Comment from Greenspace

This application is looking for the discharge of Condition 4 of application AW/179/14/PL

APPLICATION NO: AW/73/17/DOC

Description of Works: Application for approval of matters reserved by condition imposed under AW/179/14/PL relating to condition 4 for

PROJECT	Kings Parade	DATE	05/03/17
TITLE	Landscaping Plan	DRG NO	IBA/458/LA 1
SCALE	As Noted	REVISIONS	A

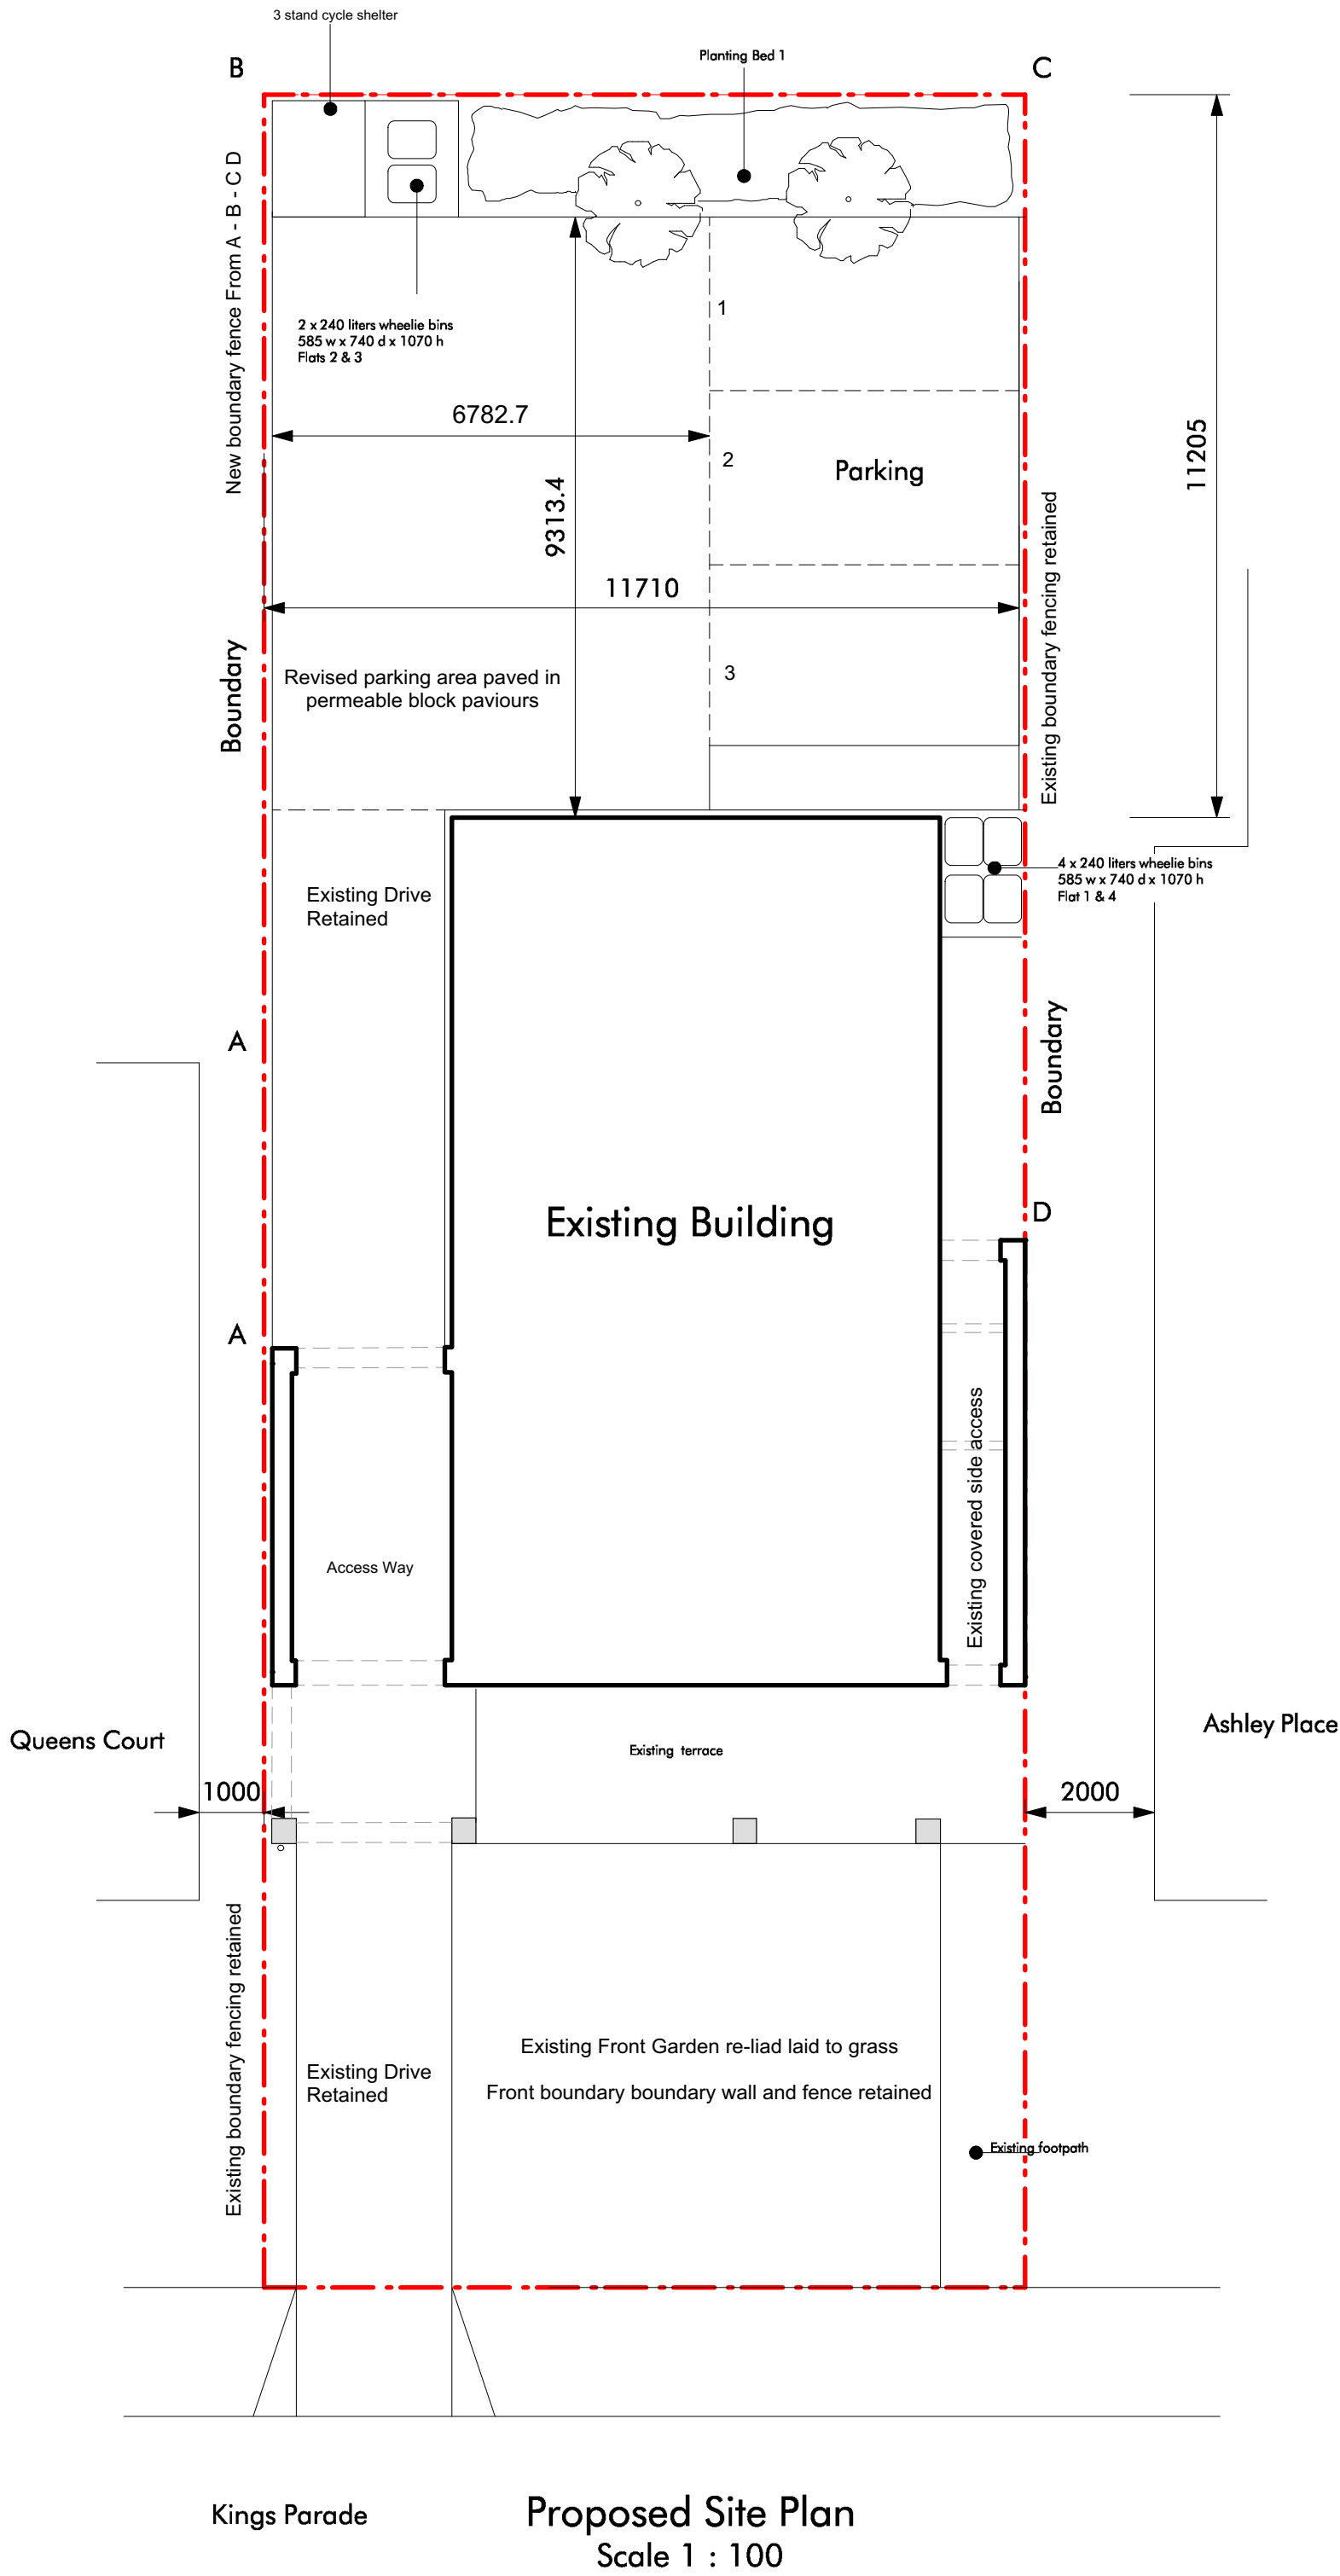
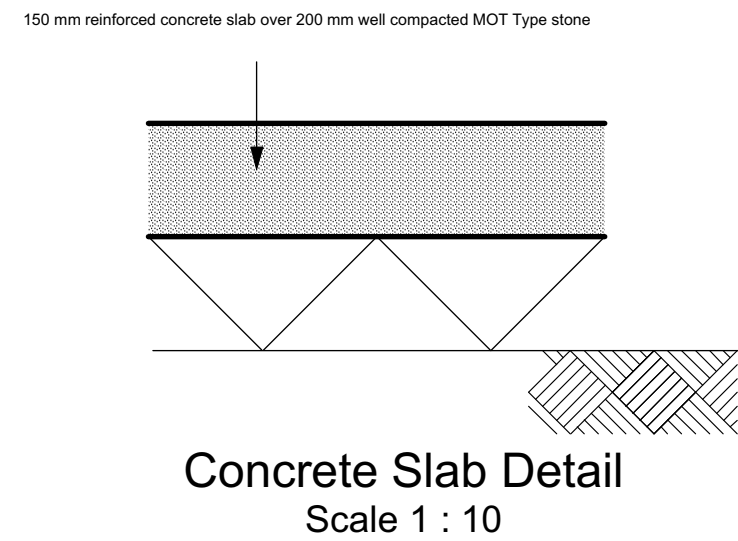
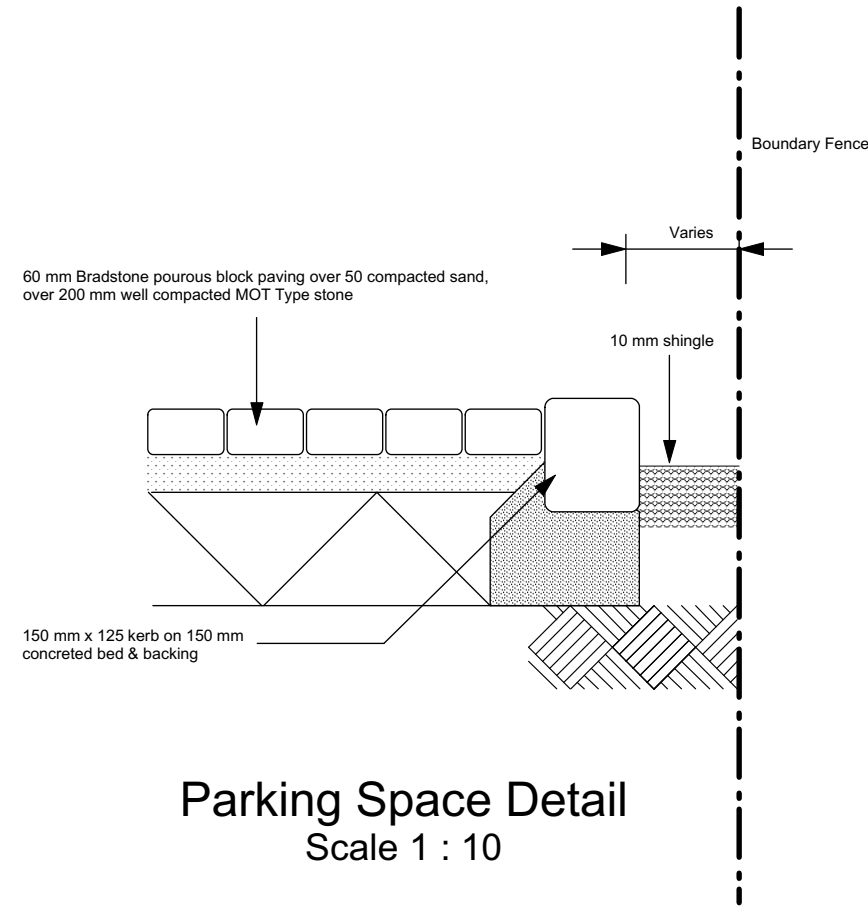
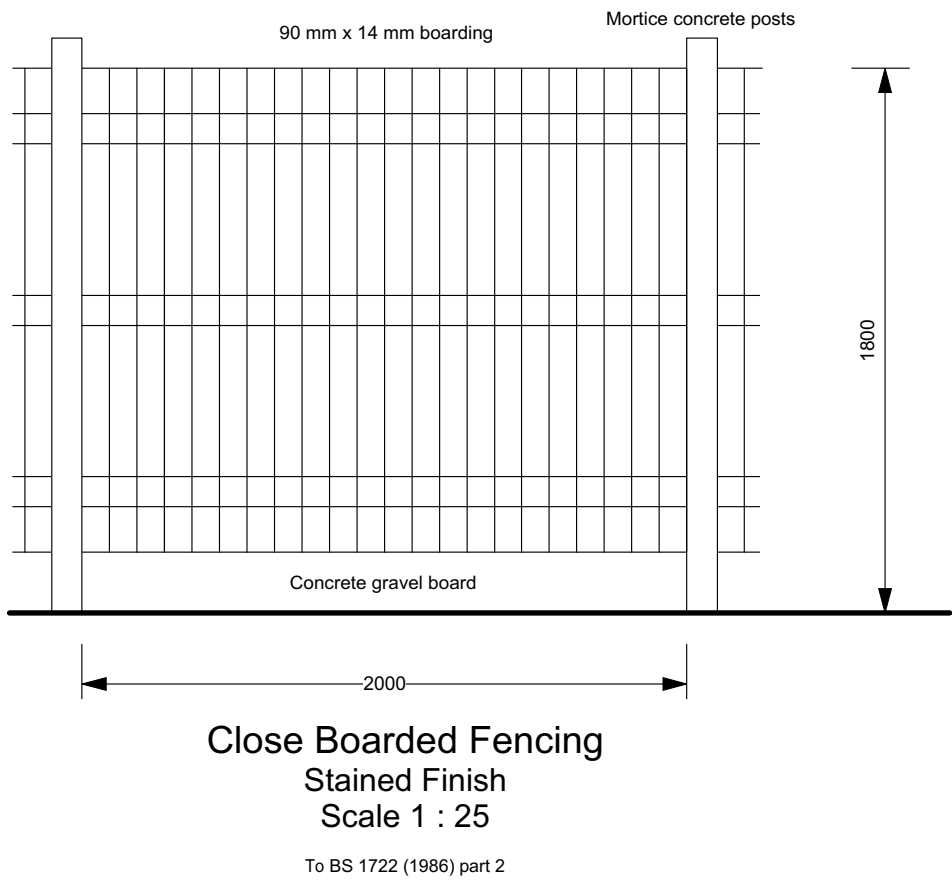
This information provided in DWG IBA/458/LA/1 needs to list the quantity of shrubs in number form and also size at time of planting.

There is insufficient information submitted and therefore would not recommend the discharge of Condition 4 on application AW/73/17/DOC.
